# ENG-PUDSP21001-R2-PDR-Redlines.pdf Markup Summary

THE VILLAS AT
 CLAREMONT RANCH
 PROPOSED DRAINAGE
 MAP

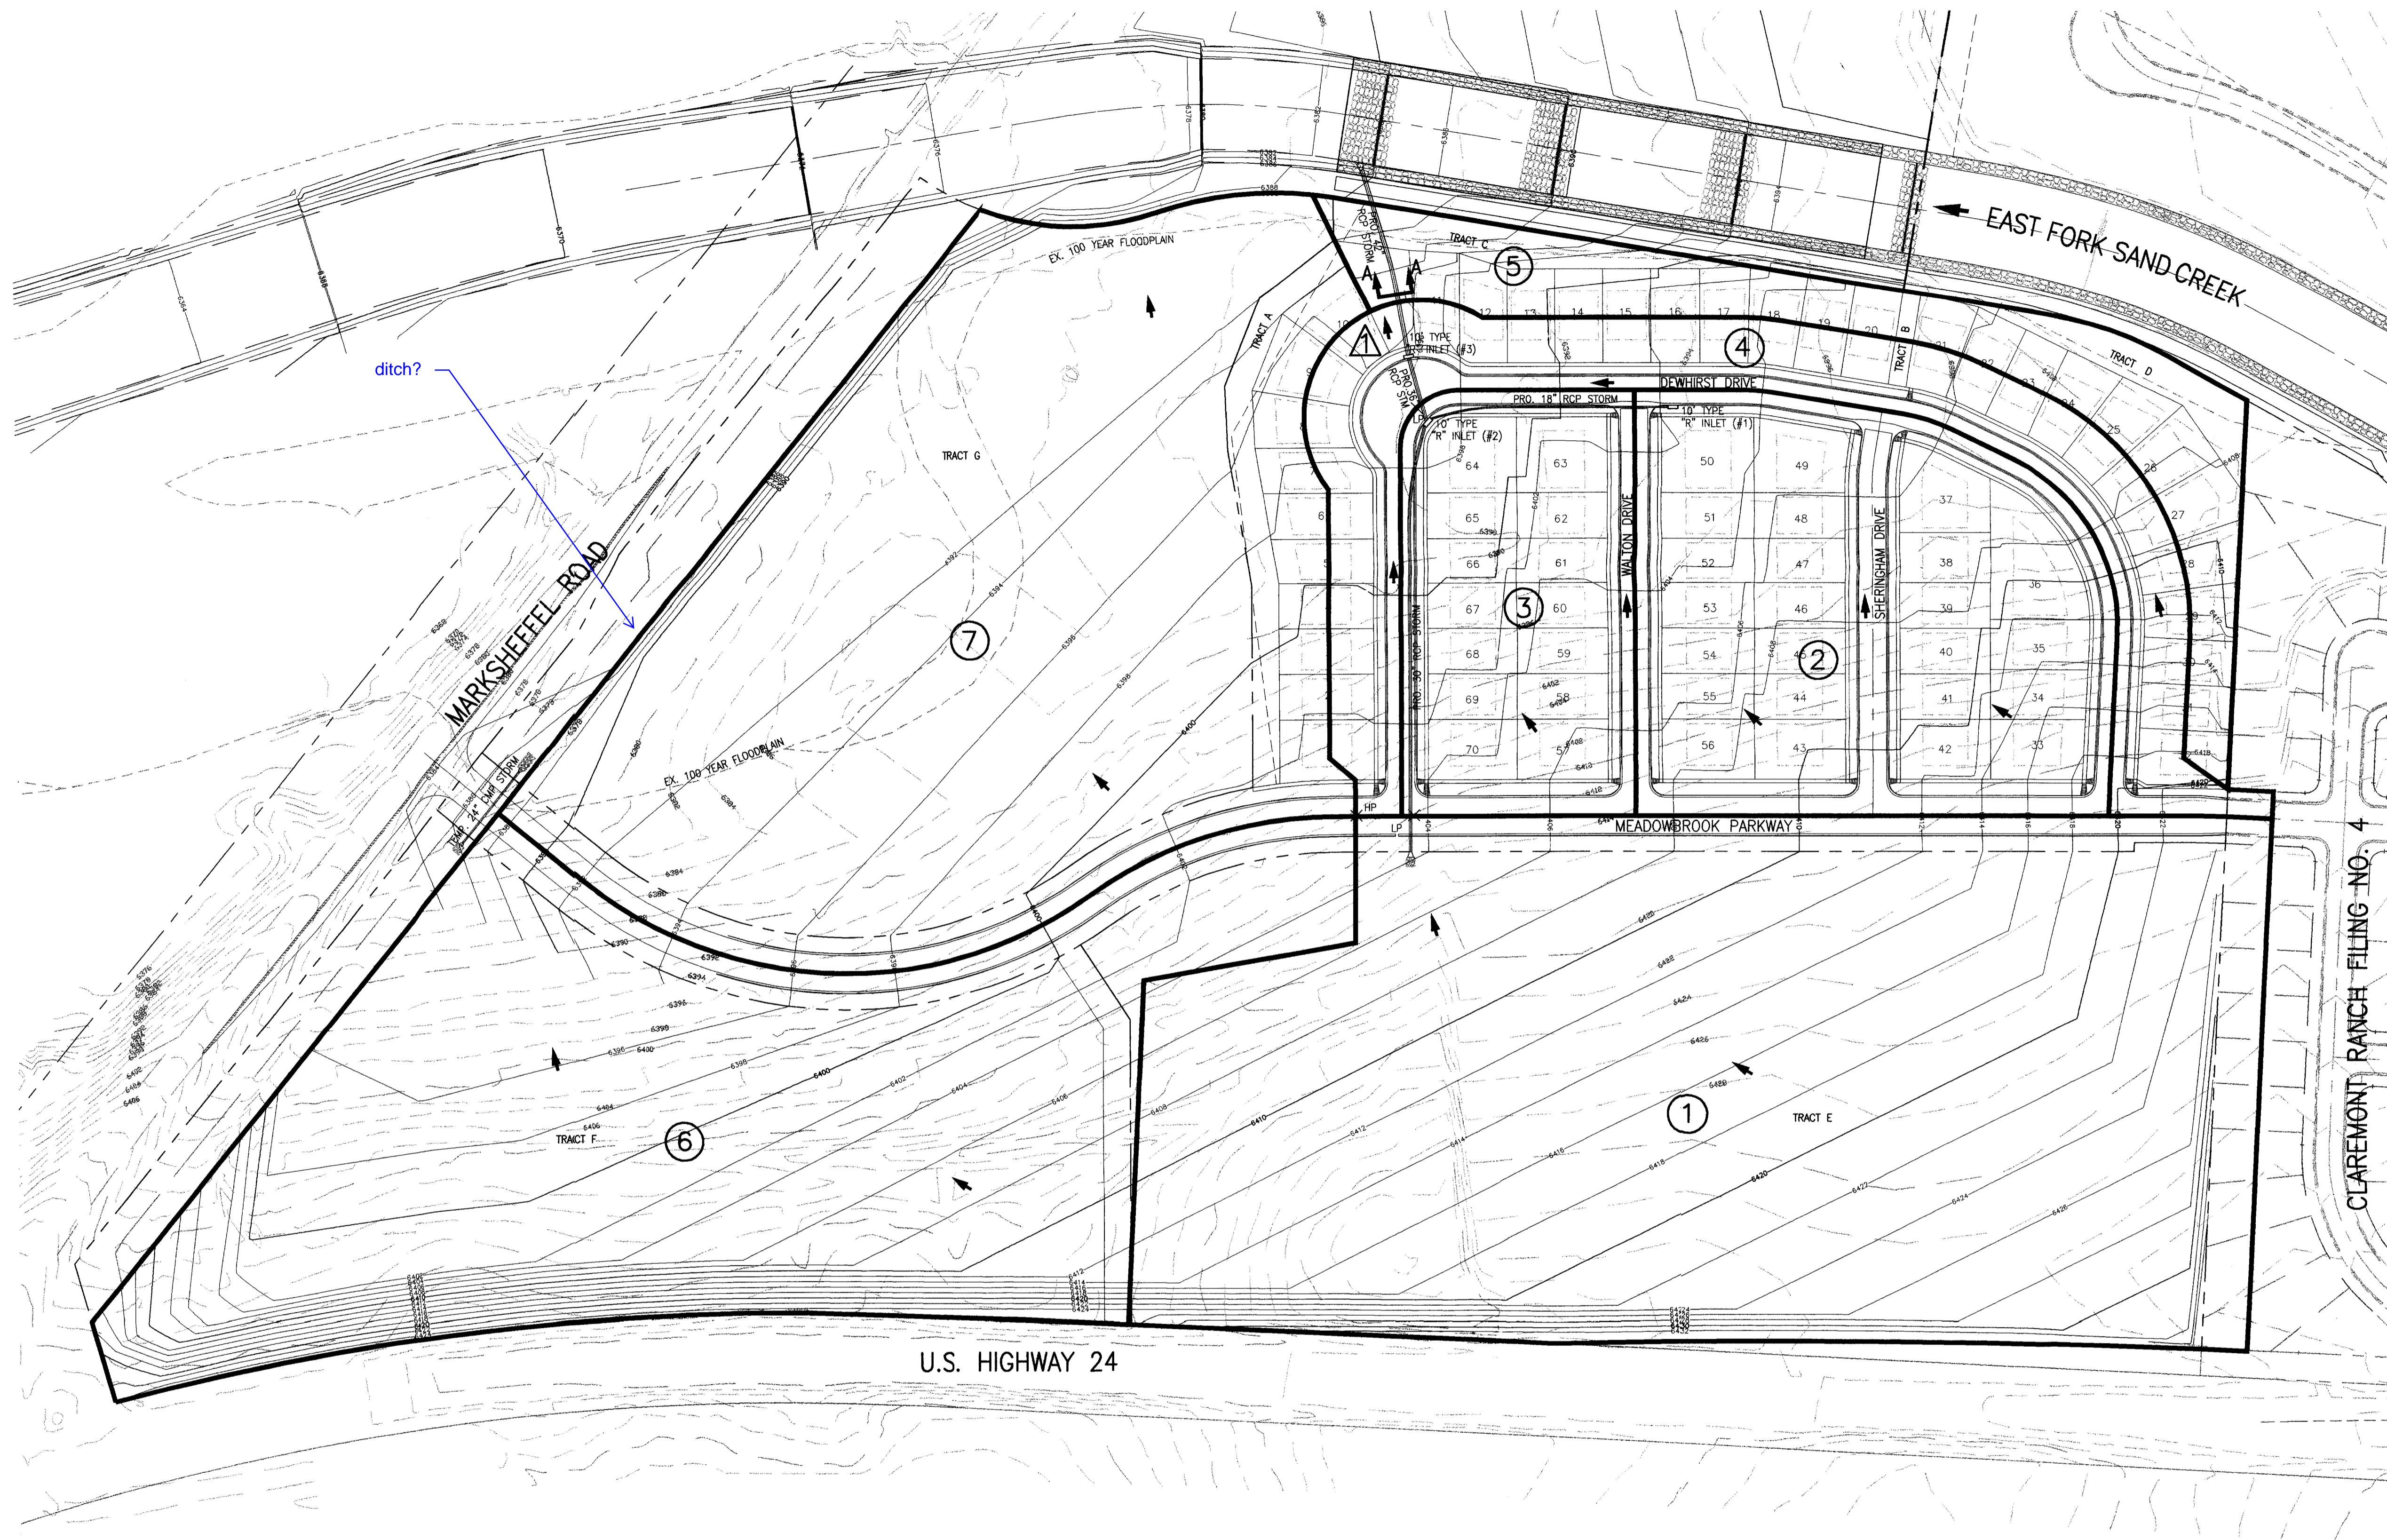
ditch?

Verify volumes and elevations shown.

Show and address in report how overflow is conveyed under/over existing trail.

Maintenance access must be no farther than 24 feet from forebay, pond bottom, or outlet structure.

Show existing contours

Sidewalk chase?

Inundation area at 92

Inundation area at FSD spillway overflow? This will affect building floor elevations.
